City of Albuquerque

RE: DRAINAGE PLAN FOR SUNWEST BANK @ SIXTH & LOMAS
(J-14/D62) ENGINEER'S STAMP DATED JULY 10, 1986

A preliminary review of your submittal for Building Permit approval has shown that the following information is lacking for this section to begin the review process:

SHEET NO.
C-2

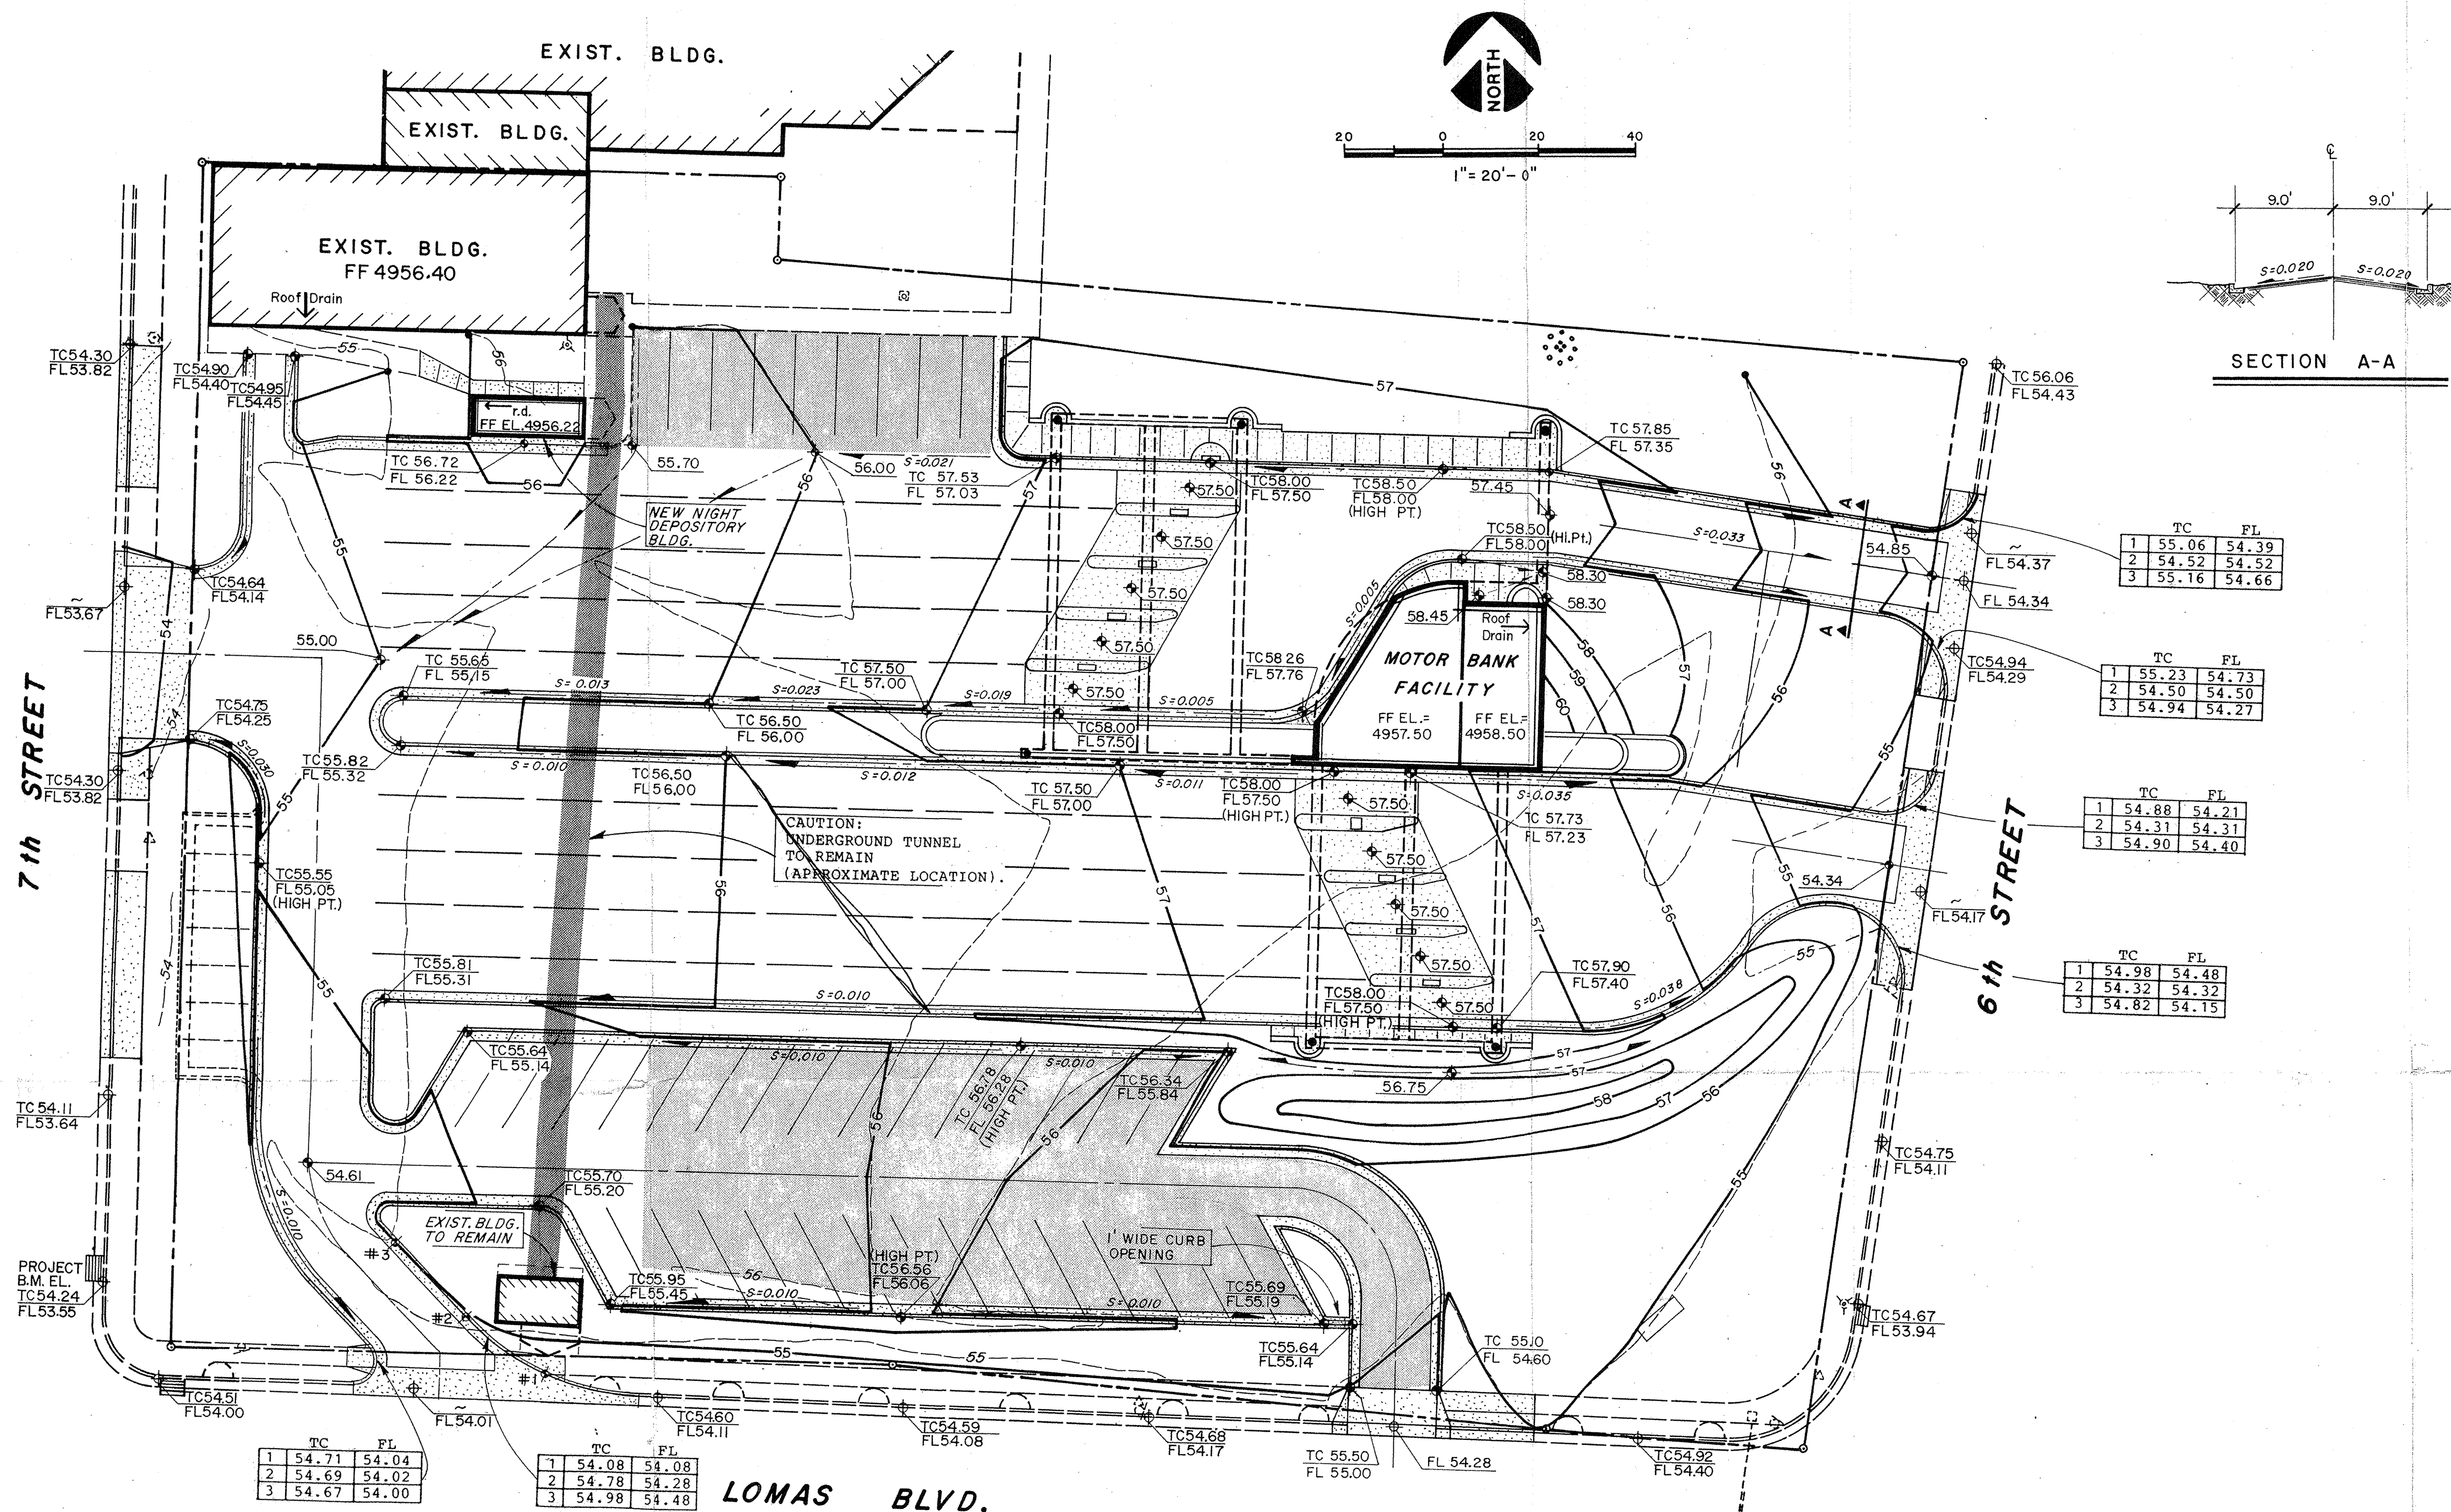
1. You will need to identify to the contractor what type of erosion control will be appropriate.
